Marulan South Quarry

Submissions Report

Boral Resources (NSW) Pty Ltd

December 2006

Figure 6: Heritage Management Area and Proposed Offset Area

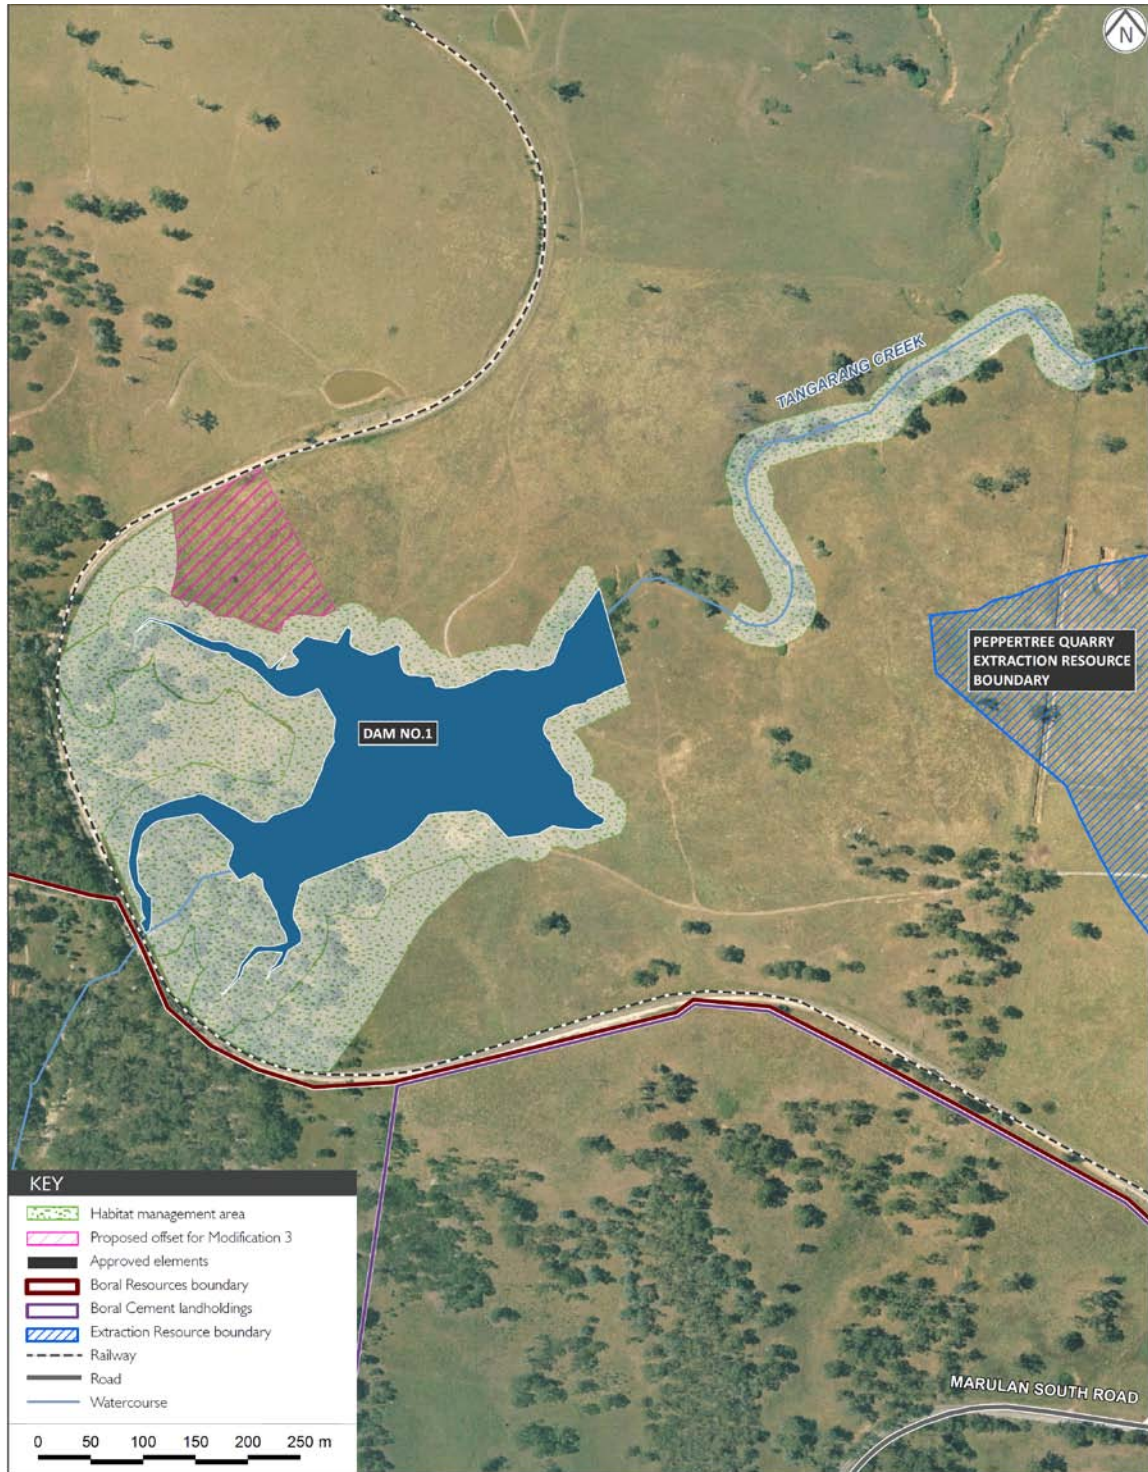
<i>Threatened species and their habitat</i>	- Considers the loss of 2.6ha of Box-Gum woodland EEC significant in the local context given the generally poor condition of the remaining EEC in the region 2.6ha of EEC at Dam 1 site should be retained and subject to improved management strategies, or - Offset area should be at least 26ha (10:1 offset ratio) and should improve management of existing EEC rather than replanting of cleared paddocks. Necessary replanting should be at dam margins and along Tangarang Cr line and should include the EECs shrub and ground layer as well as tree species
<i>Aboriginal Heritage Assessment</i>	- Concern that the assessment was not undertaken in accordance with the draft "Guidelines for Aboriginal Cultural heritage Impact Assessment and Community Consultation" and as such DEC disagrees that there is no known ethnohistorical or post contact history relevant to the proposal - Management strategy to be included for the discovery of unanticipated Aboriginal objects of significance - DEC has not received site recording forms for the November 2005 and March 2006 surveys as legally required

An environmental offset program is proposed to achieve net environmental improvement in biodiversity values at the site to offset against the loss of 2.6 ha of Box-Gum Woodland. This conceptual plan has been developed in accordance with the principles contained in the EPA 2002 Concept Paper – Green Offsets for Sustainable Development and DEC's BioMetric Assessment Tool for the NSW Property Vegetation Plan.

A Habitat Management Area will be established around the area of Box-Gum Woodland to be retained and around the periphery of Dam No. 1 and Tangarang Creek to enhance and protect the area from development for the life of the quarry as shown on *Figure 1*. The Habitat Management Area will be protected from future quarrying and will include active management of the Box-Gum Woodland to be retained and the establishment of new areas of Box-Gum Woodland. The boundaries shown are indicative only and are subject to change following survey and design.
